From: Anita Gardner
Sent: 23 May 2013 13:40
To: Planning.Responses
Subject: FW: EP/111/12 Amended wording to submission 23_05_2013

Hi,
I would be grateful if my online objection (below) could be corrected under Drainage, last sentence of first paragraph, to read :-

STREET SCENES

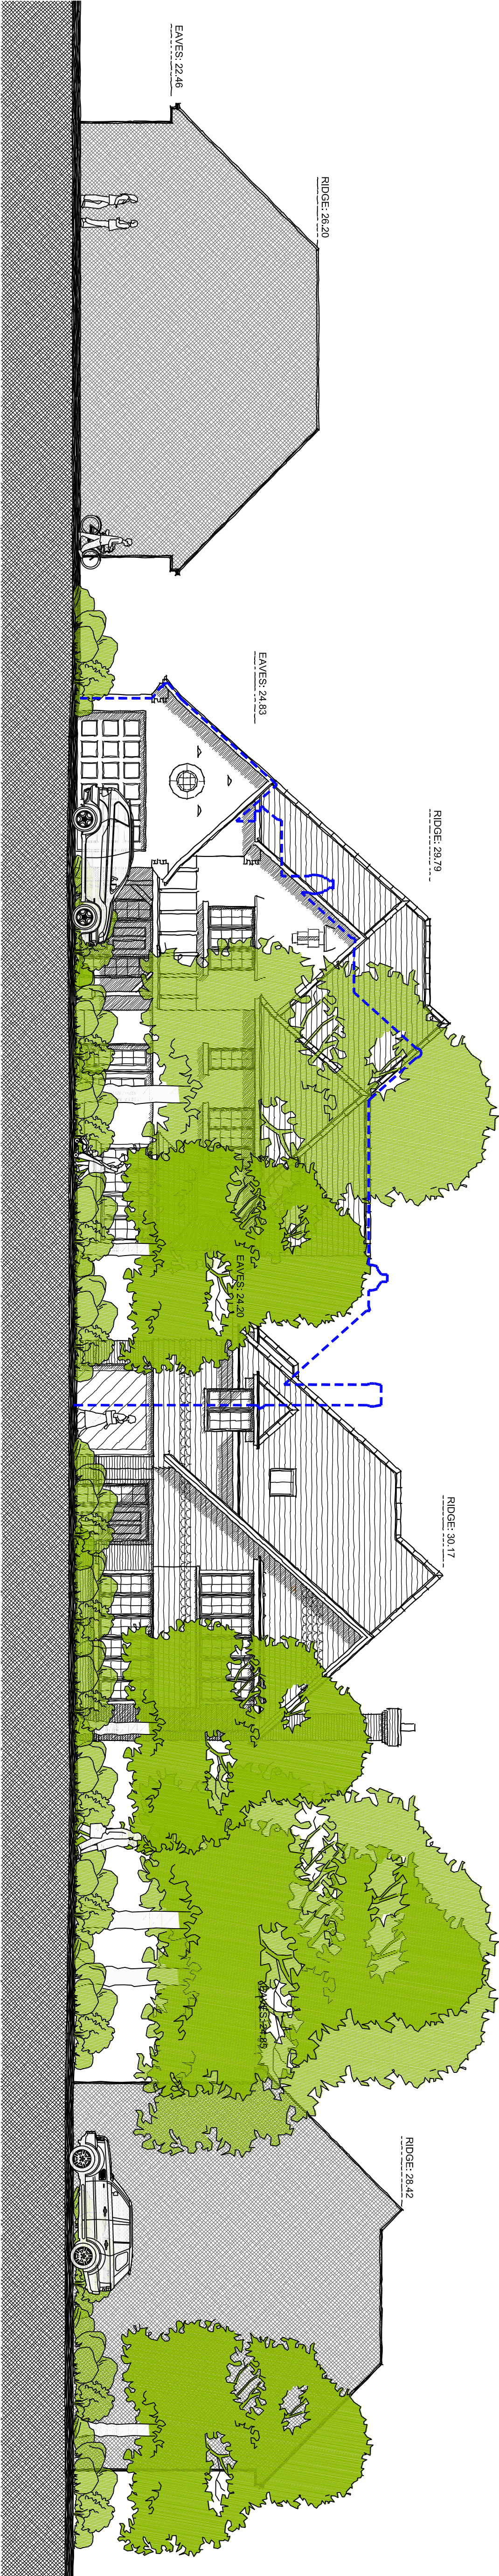
Design : The design of the dwellings is not in keeping with surrounding properties, and are overbearing in design and in roof height especially to neighbouring dwellings. This is particularly so for 43 The Ridings.
